# CITY OF ALBUQUERQUE

**Re: Hartman Publishing, 8529 Indian School Road NE , Traffic Circulation  
Layout  
Architect's Stamp dated 4-10-13 (H20-D041)**

Based upon the information provided in your submittal received 4-11-13, the above referenced plan cannot be approved for Building Permit until the following comments are addressed:

TCL.01

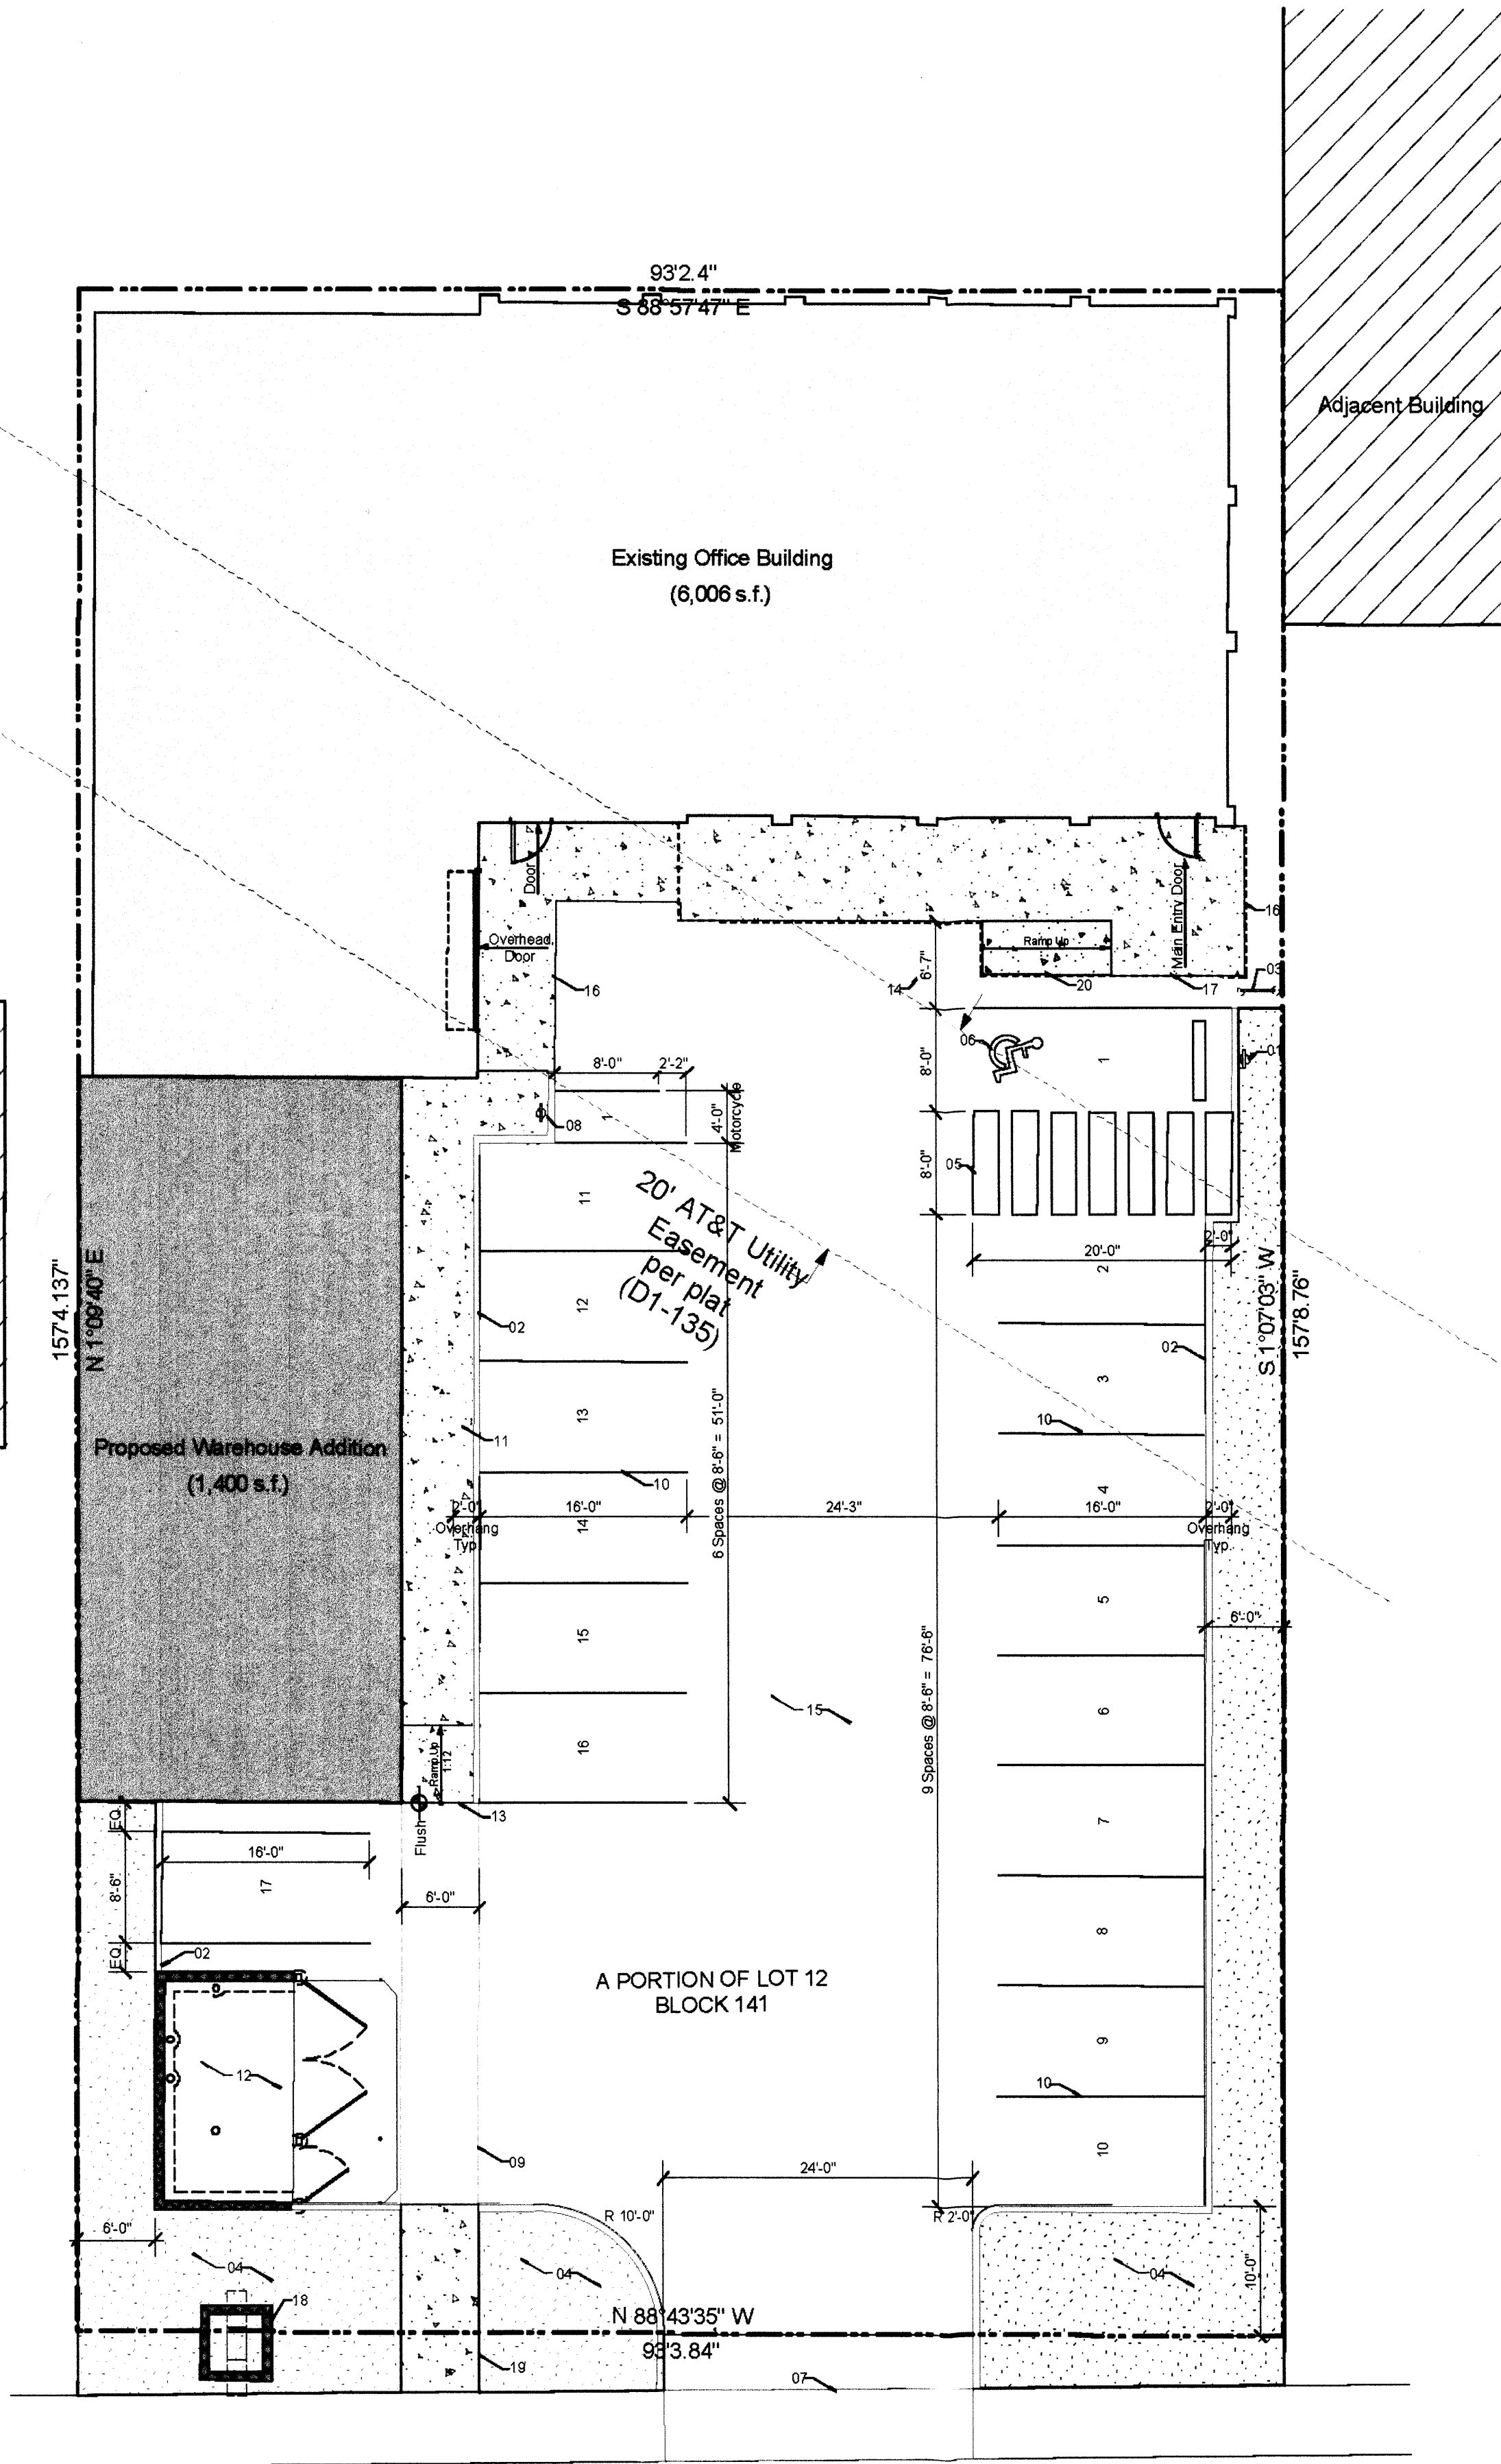
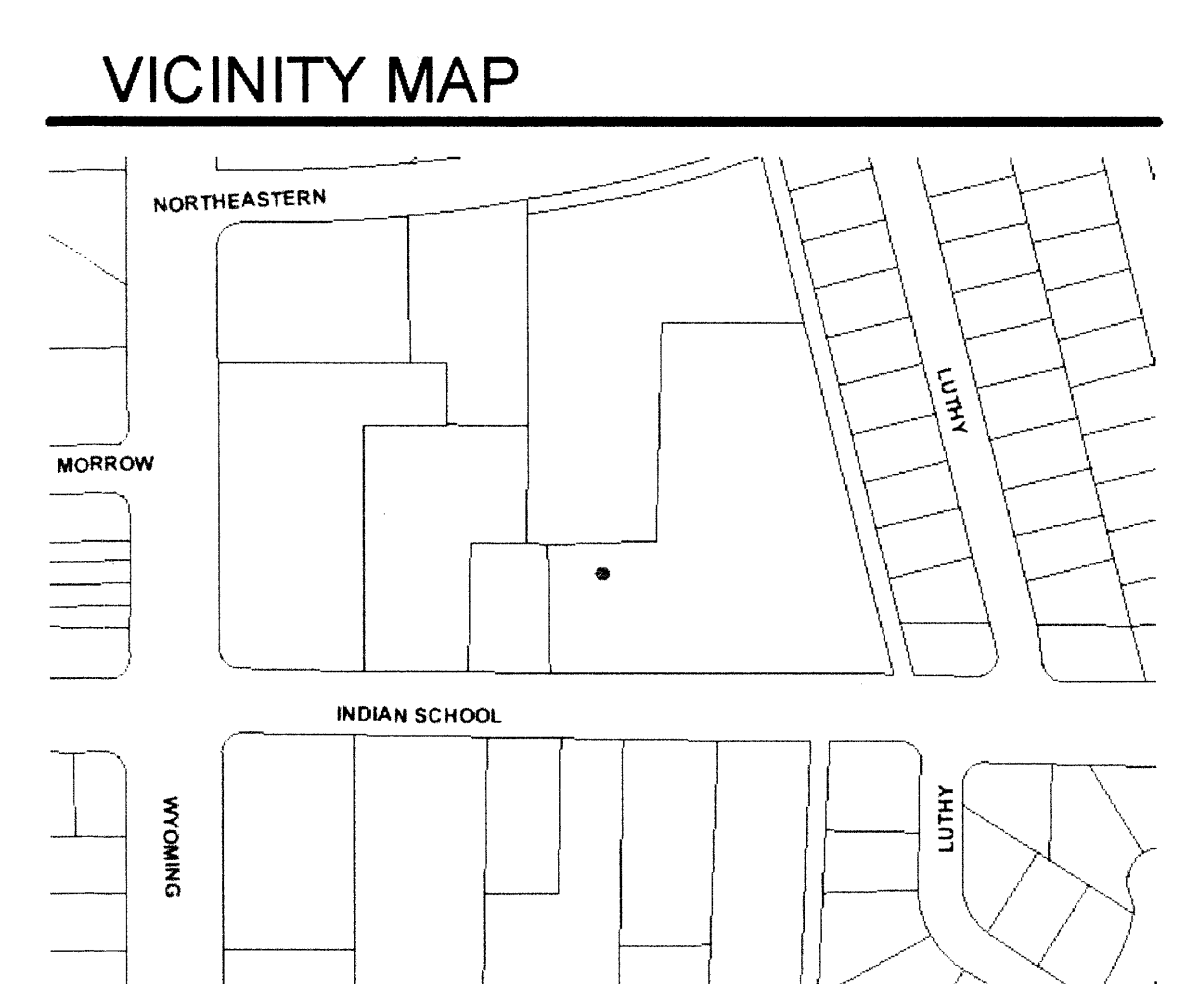
1. Please refer to all applicable city standards.
2. Please ensure all ramps are ADA compliant.
3. List the width of the existing drivepads.
4. Define width of the existing sidewalk.

5. Any abandoned or unused drivepads must be removed and replaced with City of Albuquerque (COA) standard designs for curb, gutter and sidewalk. Please label site plan accordingly, including standard drawings or provide details.

6. Since Indian School Rd is an arterial roadway, driveways with right in / right out only have a minimum driveway width of 30 feet (see the *Development Process Manual*, Chapter 23, Section 6, Part B.8).

7. If the site has left turn access, the drivepad has a 36-foot minimum width.
8. Please label and detail the proposed driveway.
9. Show a detail of the wheelchair ramps located at the proposed driveway, or refer to the appropriate city standard.

10. The turn-out radius recommended is 25 ft to accommodate refuse truck and for access to / from arterial roads.
11. Work within the public right of way requires a work order with DRC approved plans.

12. The existing pylon sign may interfere with the sight distance of the intersection. Please provide a sight distance exhibit (see the *Development Process Manual*, Chapter 23, Part B, Section 5.a).

13. The existing sign appears to be located within the COA ROW. Is there a COA Revocable Permit for this sign?

14. According to COA AGIS, the site's western property line extends beyond the limits provided by the TCL. Please clarify.
15. Please include a copy of your shared access agreement with the adjacent property owner if the site does in fact share access.
16. Please provide details of the existing ramp (keyed note 20) to ensure it is ADA compliant.
17. Parking stalls providing 16 foot lengths with a 2 foot overhang must comply with the DPM. A six foot unobstructed ADA accessible pedestrian pathway must be provided from the COA ROW to the buildings entrance. Additionally, vehicles can not overhang vegetative landscaping.
18. The pedestrian connection, key note 19, does not indicate pavement marking on asphalt to connect sidewalks. Please clarify.
